TECHNICAL MEMORANDUM

Project	11863 Grundon Services, Banbury		
Date	26 October 2020	Memo No	M003
Memo to	Mark Berry, JSA Planning	Copies to	-
From	Mat Tuora MIOA	Checked by	Adrian James FIOA
Filename	11863 M003.docx

REPLIES TO QUESTIONS RAISED BY TREVOR DIXON ON 4 AUGUST 2020

Figure 4 – External daytime levels across the site at 1.5m height (LAeq,T) if the train noise source height is taken to be 4m

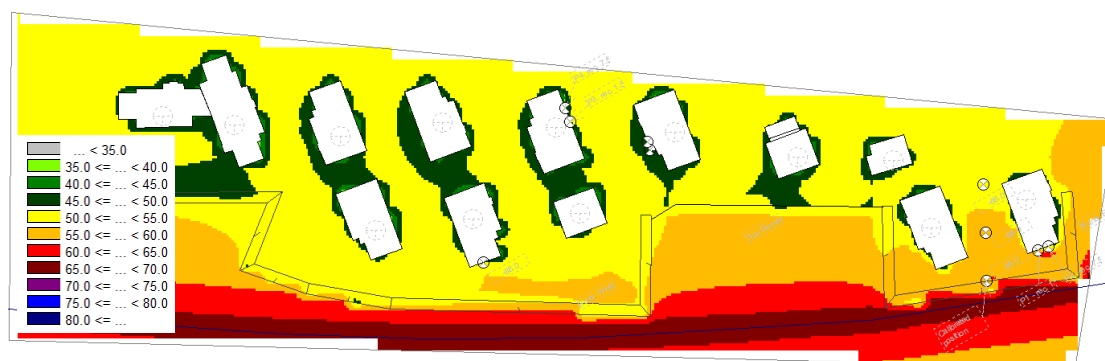
External daytime levels at a height of 1.5 metres are mostly within the desirable level of 50dB or the upper level of 55dB with a 6 meter barrier (bund and/or acoustic fence) in place. However, the barrier will only be effective at mitigating low level noise sources for example wheel noise on the rails that are close to the barrier, and protect ground floor dwellings and amenity areas. For diesel locomotives running on full power where the source height is 4 metres and sources further from the barrier such as the LMD, the barrier will offer less protection and no protection to the upper storeys. Also, the rail line is approximately 1.5 metres higher than the site towards the south east end of the site and it is not clear if this been accounted for in the barrier calculations.

The question is not correct. The CadnaA noise model used in our calculations takes account of the site topography and including the existing height of the railway line and the proposed heights of the barrier and buildings relative to this. This is intrinsic to the CadnaA noise modelling methodology. The figure below shows a section through part of the site showing the different heights of the railway line, the barrier, and the receptors.

We have therefore accounted for the elevated ground to the south east of the site. Our model assumes a train line height of 0.25 metres to the South-West and 1.5 metres to the South-East.

Because of the difficulty of separating wheel-rail noise and locomotive noise in the measurement process, for our calculations we have assumed that all train noise, including that from the wheel-rail interaction, comes from a height of 4 metres. This represents a “Worse than worst case” condition and our calculations are therefore likely to overestimate the resulting noise levels.

It is well known that barriers are less effective for sources and receivers at higher elevations, particularly if a noise source has a clear line of sight to the receptors. This is why the barrier has to be as much as 6 metres tall. The results are demonstrated in Figures 19 - 24 in Section 7.4 of our report 11863/2B, which show the predicted noise levels at heights of 1.5 m and 7.5 m. Noise levels at intermediate heights will, of course, be between these values.

Figure 1 -Statistical distribution of daytime background sound levels (LMD noise excluded)

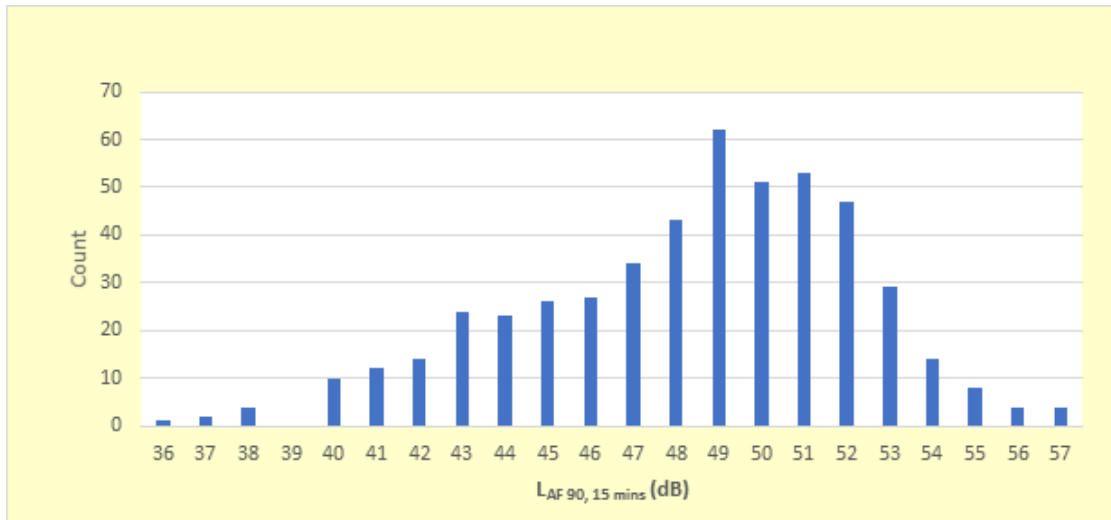
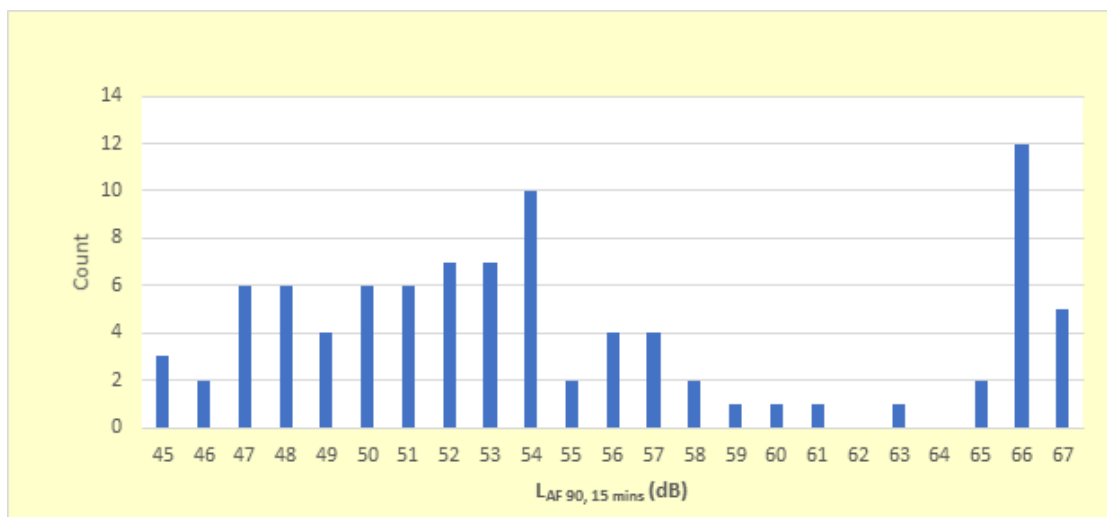
With regard to the background level it would have been useful if the raw data had been presented as an appendix in the reports so that it was possible to see the range of levels at different times of the night time period. The background should exclude noise from passing trains and the LMD because these are the noise sources of concern but include noise from the distant M40. Even using a night time background level of 49 (it is incorrectly stated again as 48 in paragraph 6 of memorandum 1863/M002 and also in Table 3 of assessment 11863/2B) the BS 4142:2014 rating level is still significant adverse impact

I had previously questioned why the night time background level is higher than the daytime level in the absence of all noise sources attributable to passing trains and the LMD and a reason given by AJA is the percentage of HGV's is higher at night. I would agree that the percentage of HGV's relative to the total traffic flow would be higher at night than during the day, but not that the number of HGV movements is greater at night. This was the reason for asking for the traffic data on which their modelling was based but the data provided only shows the average annual daily flows and not a breakdown between day and night.

In the interest of providing useful data we have included the processed data from our survey in Appendix A of this memo this is in terms of $L_{AF90,15\text{-minutes}}$. This should be far easier to review, but if the Council requires the 0.1 second log data we would be happy to provide this on an online share point. We are happy for the Council to contact us directly to discuss how the log data may best be reviewed. This data excludes contributions from train movement and activities at the Light Maintained Depot.

It must be understood that L_{AF90} represents the quietest 1 minute and 30 seconds out of a 15 minute period, hence the noise from passing of trains is unlikely to contribute significantly to this measure.

The nature of the site is such that noise from idling trains occurs for much of the night, so that the amount of useable data to calculate the background levels is limited mainly to the start of the night and end of the night. We made every effort to ensure that our data processing was accurate and, but have further reviewed the audio files and have excluded further data in which idling train noise may have affected the background measurements. Even with these additional exclusions the results still show night-time background levels of approximately 48 dB LA_{F90} and daytime background levels of approximately 45 dB LA_{F90}, which is consistent with our original findings. We have received no alternative data from the Council or any other source to contradict this.

The lowest background during the night was measured at 47 dB LA_{F90, 15 minutes}. Even if this were taken to be representative the outcome of the BS4142 assessment would remain the same. For that matter even if the background at night was significantly lower than this the assessment would still remain the same as the BS4142 assessment already concludes a significant adverse impact would occur without mitigation. Please refer to our reply to question 4 for the results with that mitigation.
